Date 25 September 2019

Our Ref: R/2015/37/W  
File No: 2019/446885

**SSD 7317 – MOD 17 – Building 2 – Locomotive Street Retail Reconfiguration**

Elevations - South & East

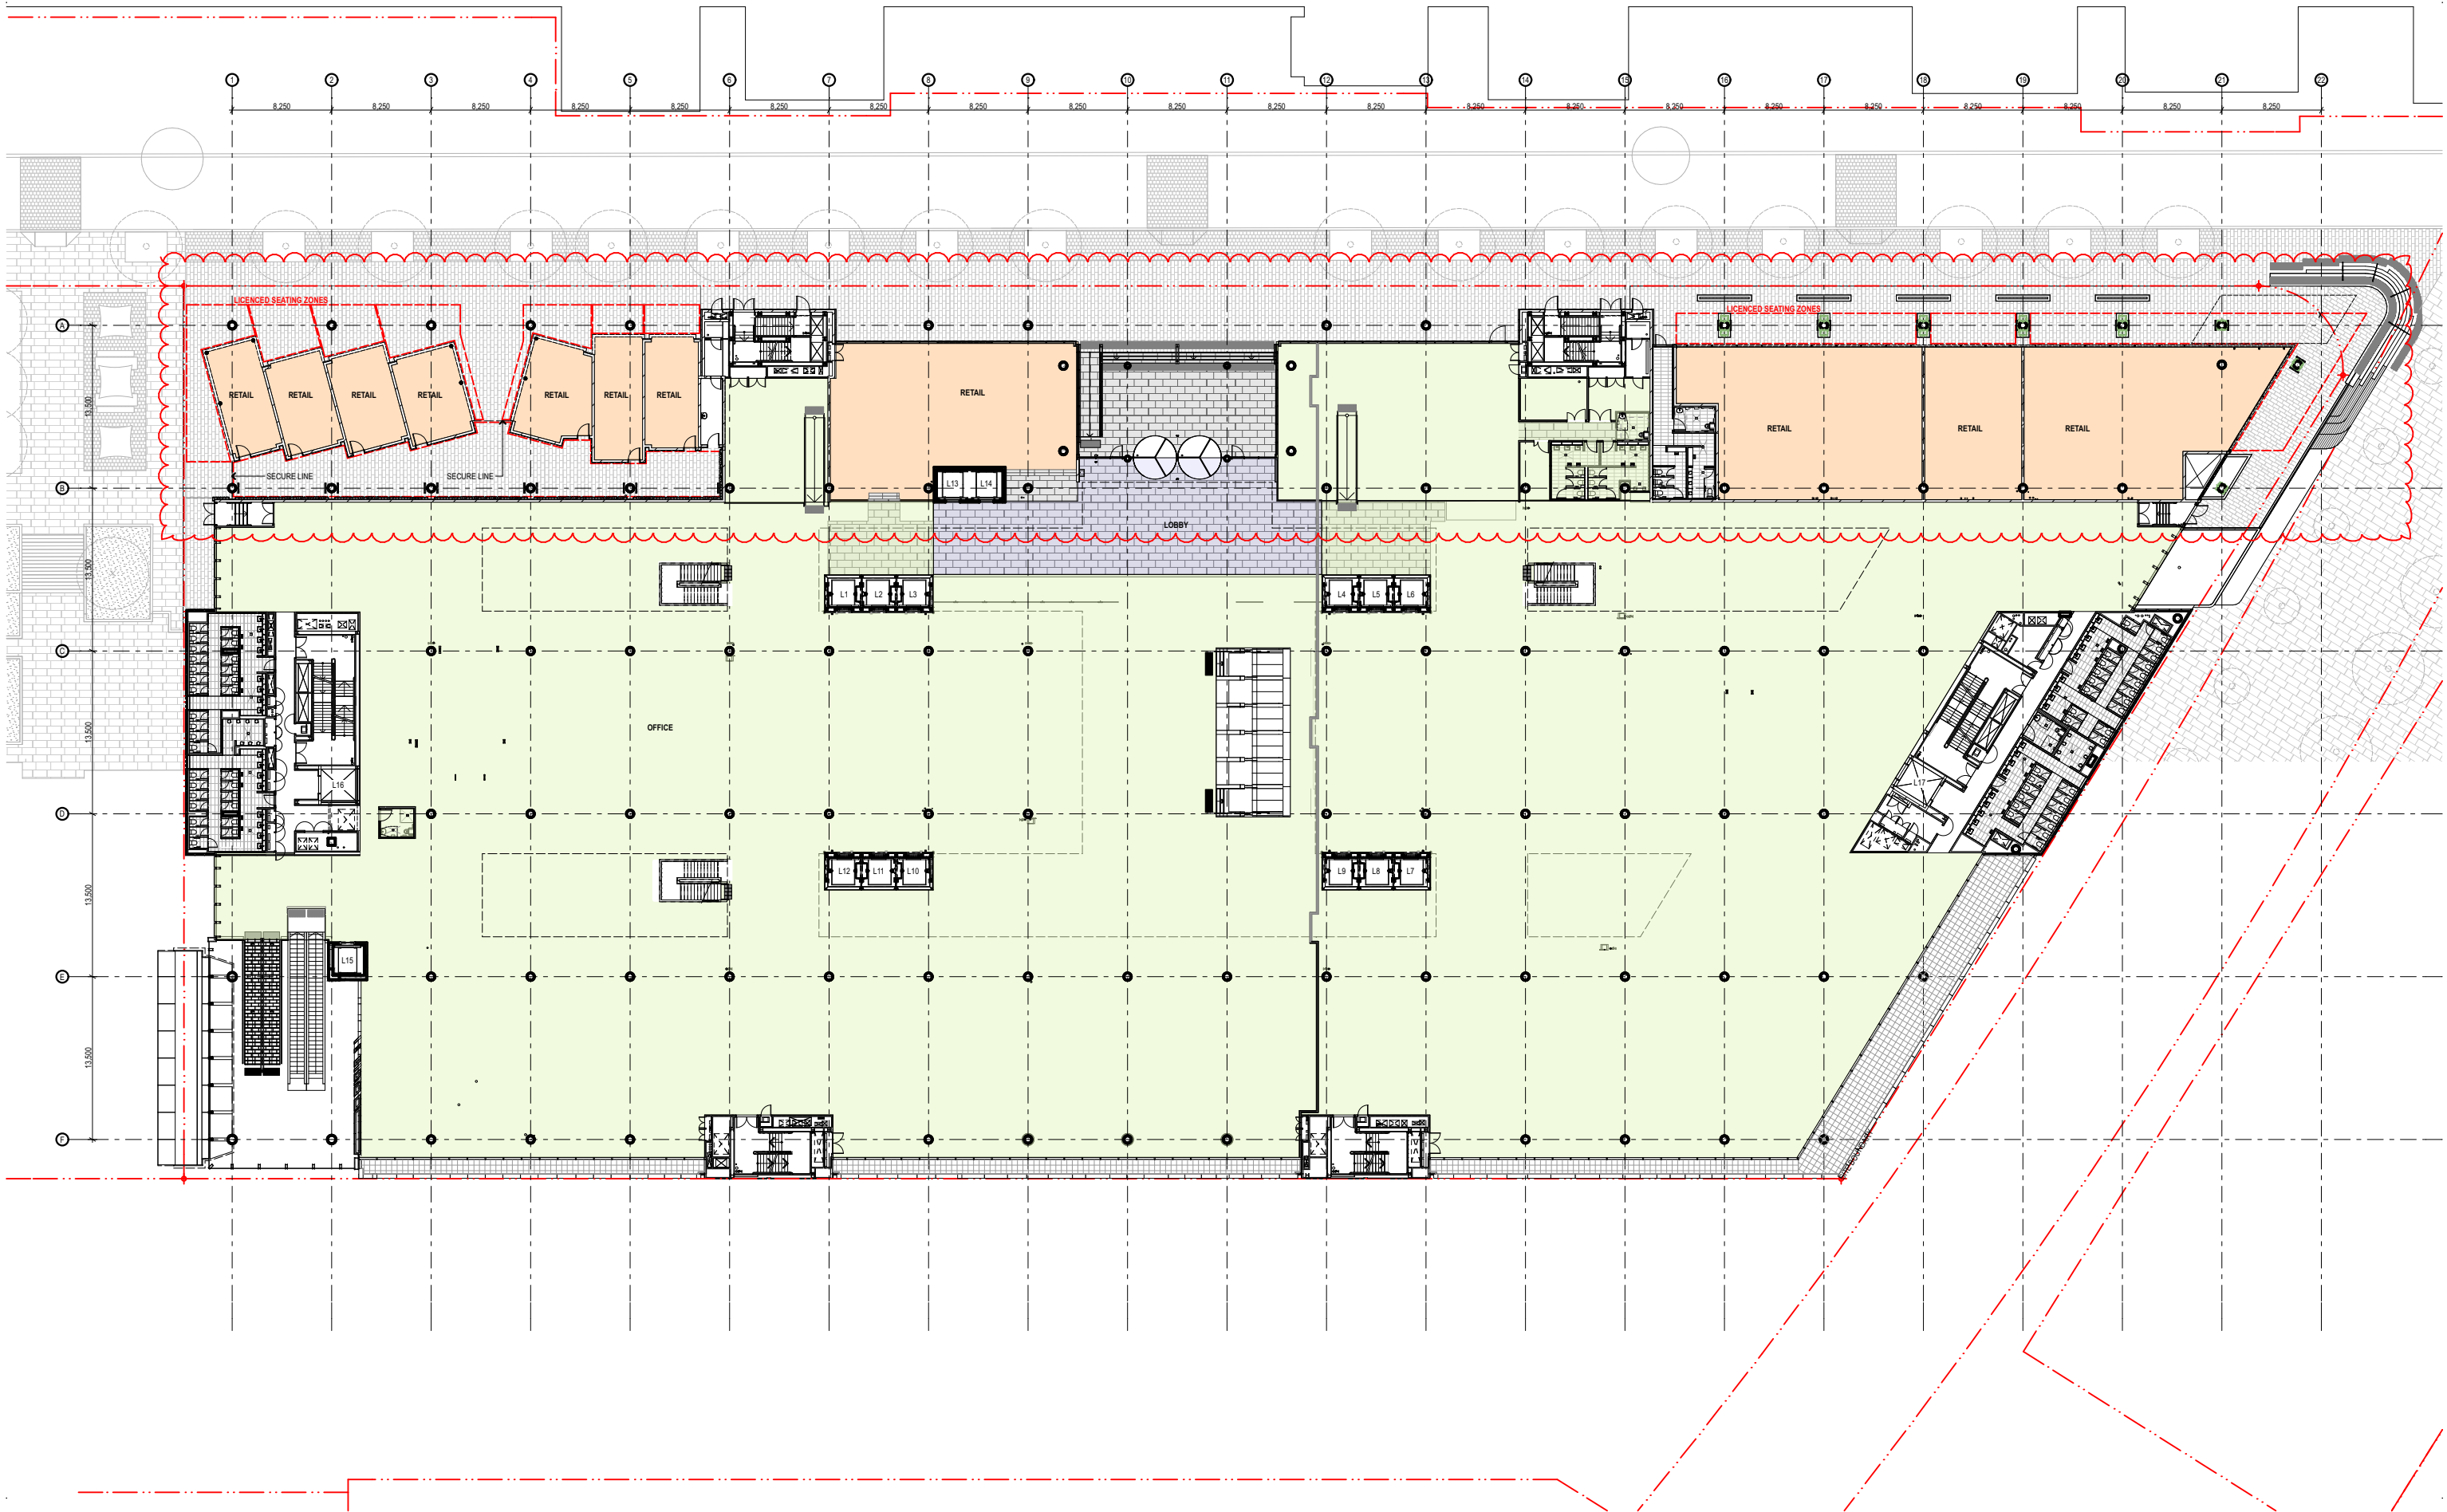
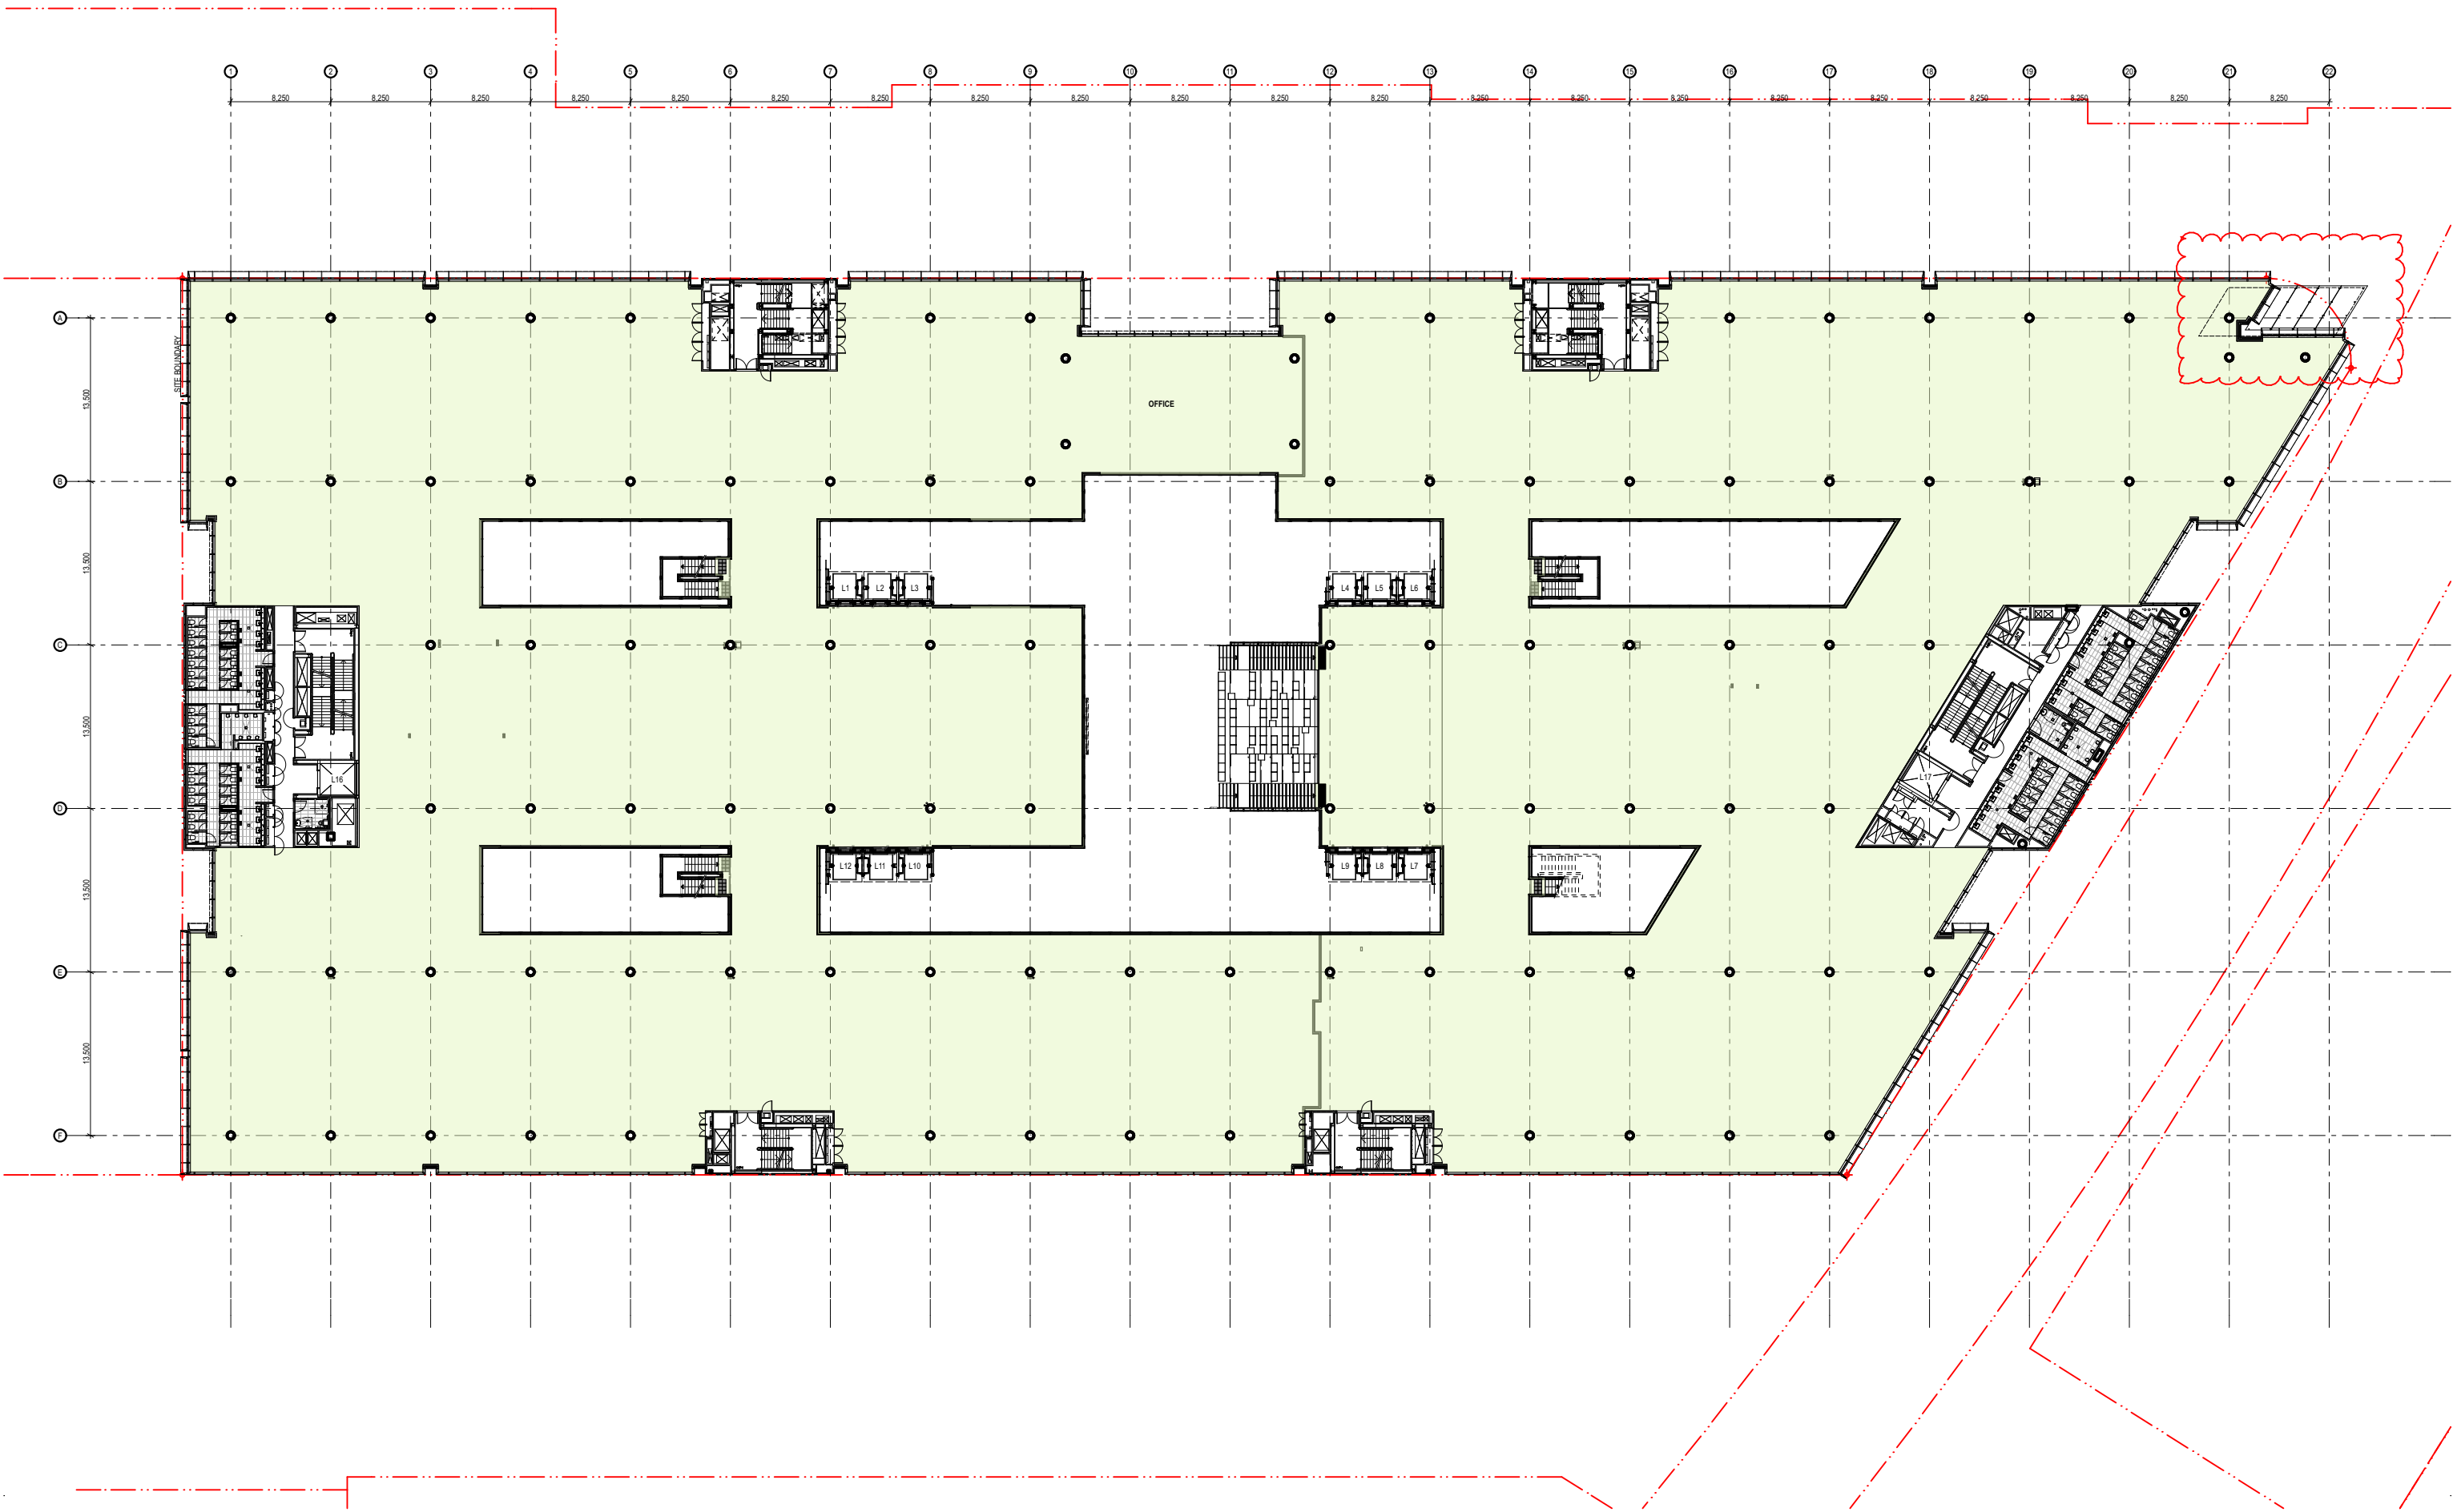
- b) The height of the proposed top of building sign of dimensions 18.3m x 3.0m should be revised so that it is no higher than 15m above ground (currently proposed at approximately 29m above ground).

- c) The size and height of the 'Indicative Signage Zone' at 9m x 1.5m in dimensions is not supported – it should be no higher than 4.5m above ground and of smaller dimensions so as to minimise visual impacts.

Figure 3 Proposed Upper Ground Floor Retail Layout for Building 2

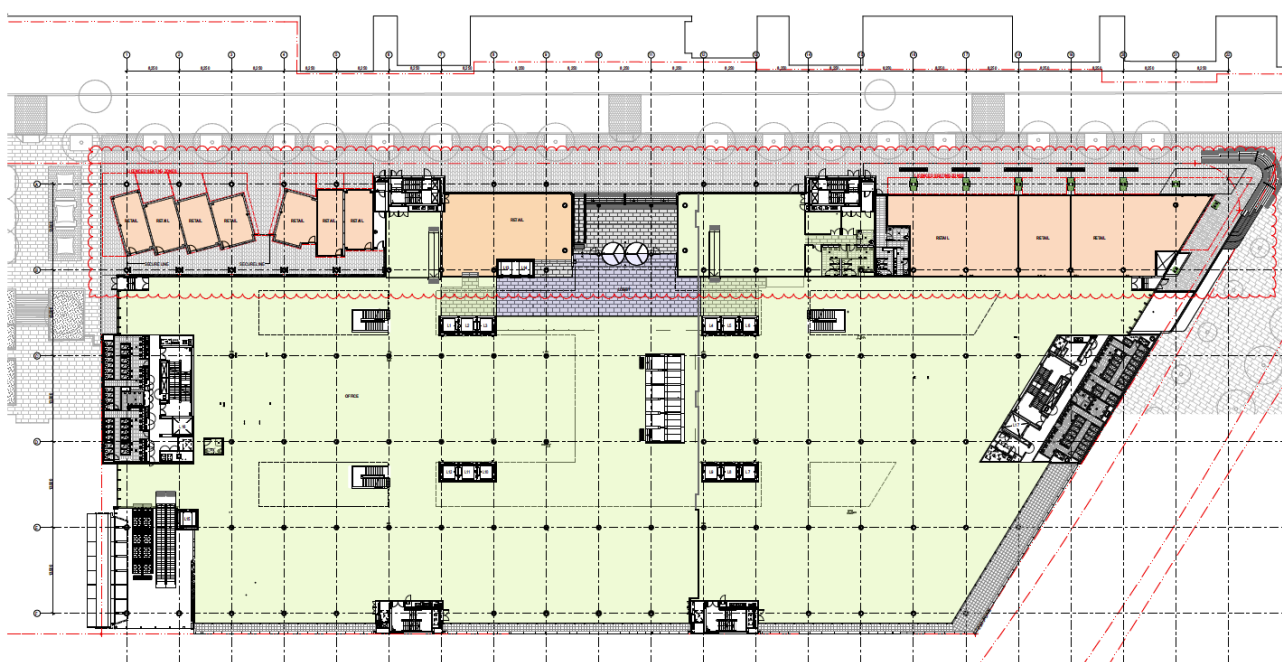
As noted during this meeting, the layout of the retail tenancies should be redesigned to allow for an additional opening next to the amenities of the north-east of the site for the rear external seating area (in blue outline below). This may result in the loss of some retail GFA but would provide for additional amenity for patrons.

Figure 5 Location of Proposed Signage Zones along Locomotive Street

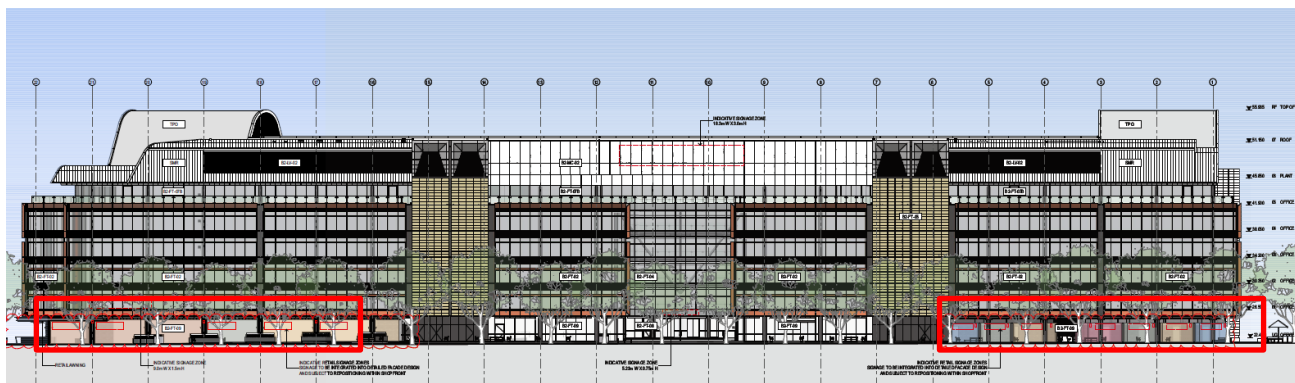
- a) The information provided for the 'Indicative Signage Zones' and 'Indicative Retail Signage Zones' is insufficient for the purposes of an assessment. The size and proposed locations of these zones, materiality and limits to the number of signs per tenancy should be confirmed via the submission of a comprehensive Signage Strategy to be endorsed in consultation with the City of Sydney. **The City objects to the signage zones unless the above is addressed.**

Figure 6 Eastern Retail Signage

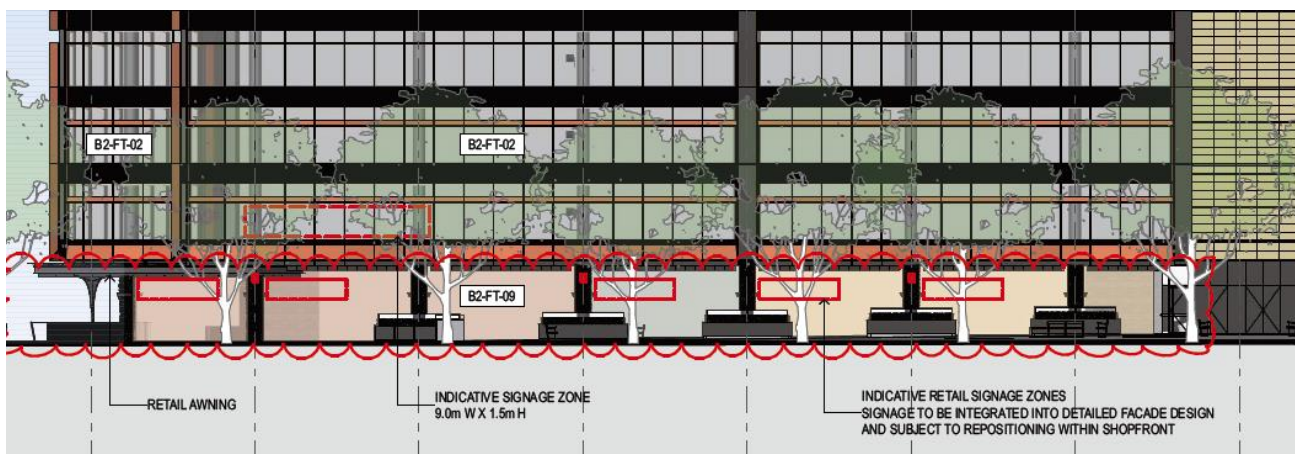
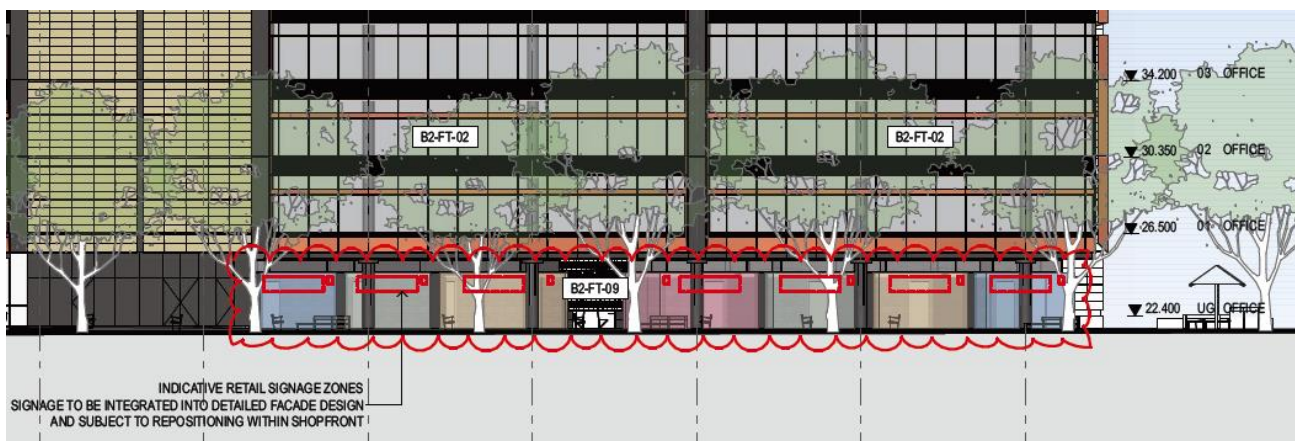
- d) The size of the 'Indicative Retail Signage Zones' is not confirmed in text, but on the scaled drawings, appears too large. Further detail on these signage zones is required by way of a Signage Strategy as discussed in point a) above.
